Application No: AW/35/21/HH
Site Address: 27 Grosvenor Gardens Aldwick PO21 3EZ
Description of works: Ground floor rear extension, first floor to have 2 bedrooms/bathroom and office, dormer roof to rear to be fitted with solar panel, gas to be taken out & roof apex to both side.

Thank you for your internet representation made on 9th April 2021 which has been recorded as an objection with the comments as follows:

OWPC35043

East Side Elevation

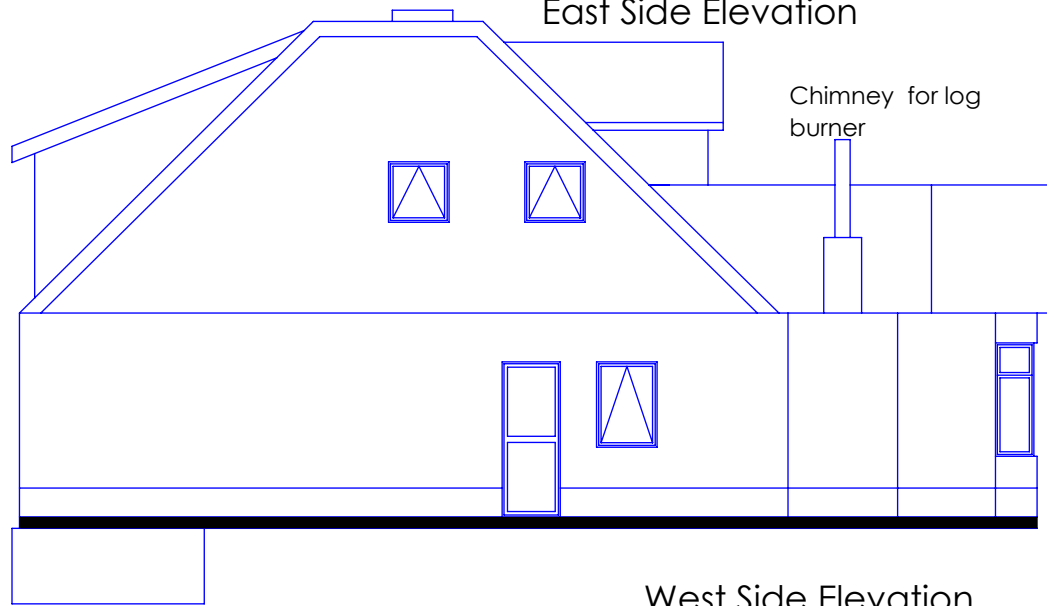
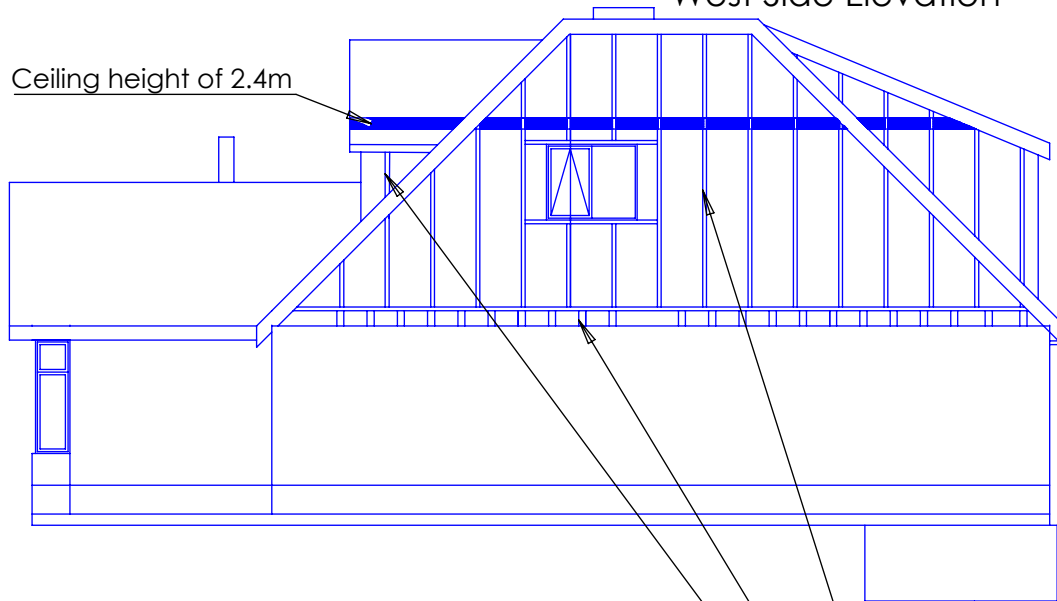
.the proposed extension and alterations do not visually integrate with the existing building in design, form/shape and materials. The property is situated in the middle of a row of 9 bungalows.

.the proposed extension and substantial alterations to the roof will have an adverse overshadowing and overbearing effect on neighbouring property - particularly on the east side as the west side is separated by two driveways.

It is proposed to remove the existing roof slopes on the east, west and south sides of the property and extend the rear by 2.5 meters. The effect of the proposed reconstruction of the roof over the rear extension will be a perpendicular high block which our main living room west facing patio door looks out to. The addition of solar panels will increase the roof height. If we were required to fit solar panels to our roof their effectiveness would be compromised.

East Side Elevation

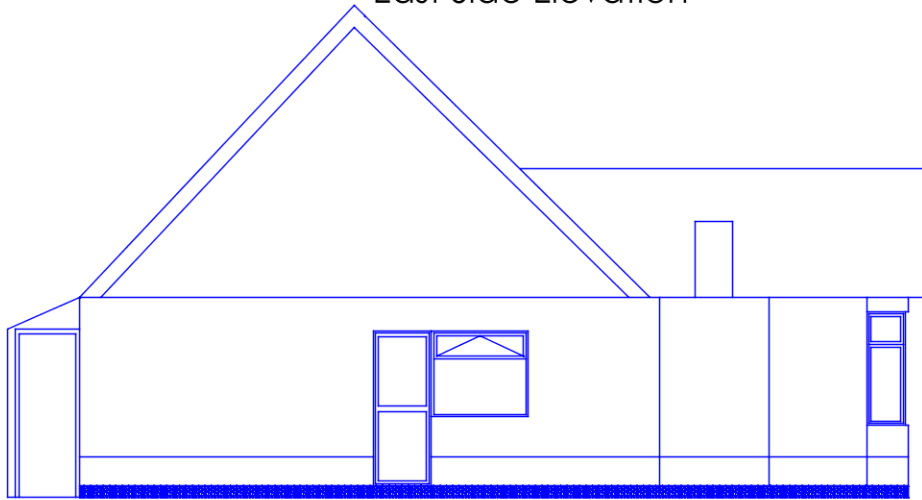
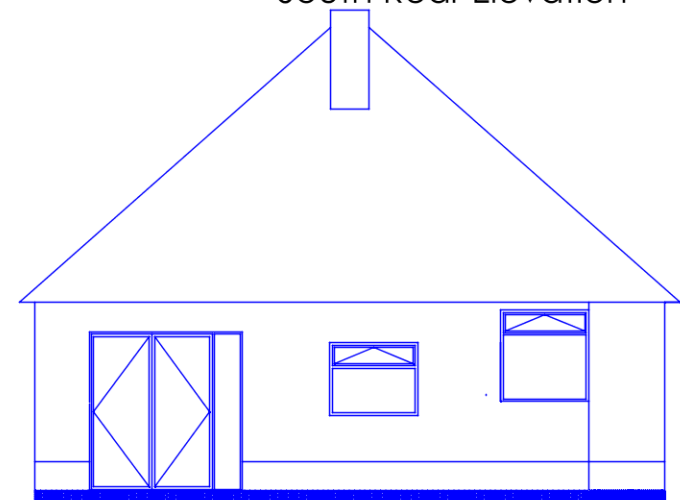
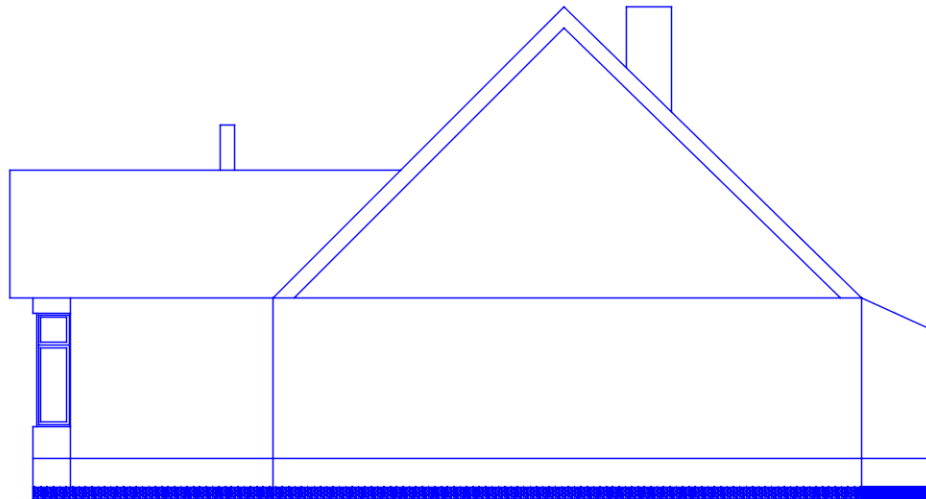
The plans submitted of the proposed extension and roof alterations do not show the full impact on neighbouring properties. Plan(s) of the existing property roof line, with the proposed changes and extensions highlighted in colour or shaded and a side street plan are necessary to show the impact on neighbouring properties.
